Rough Wall Graphics

Executive Tower

2864 S. Circle Drive
Colorado Springs, CO 80906

Markup Summary

Rectangular Survey of One Section

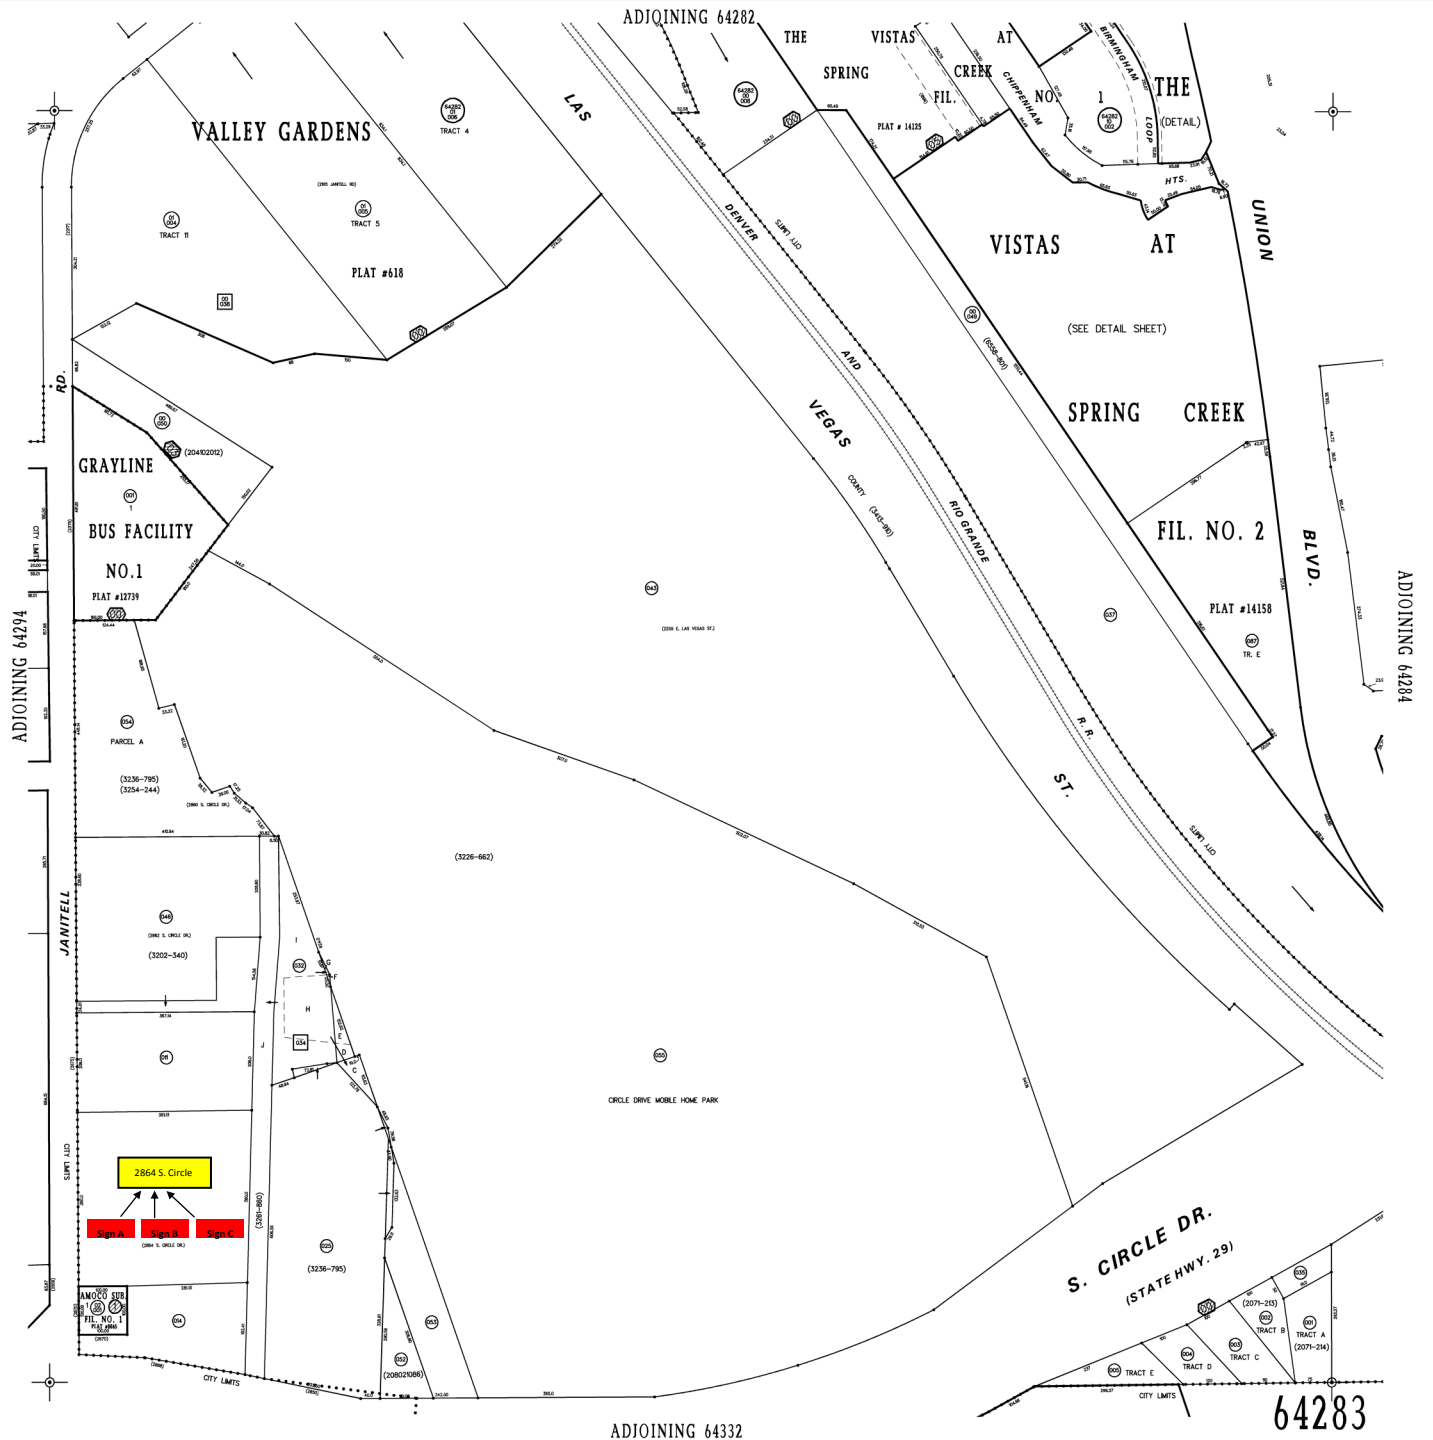
Mark where the building is located in this parcel and where the signs are located on the building.
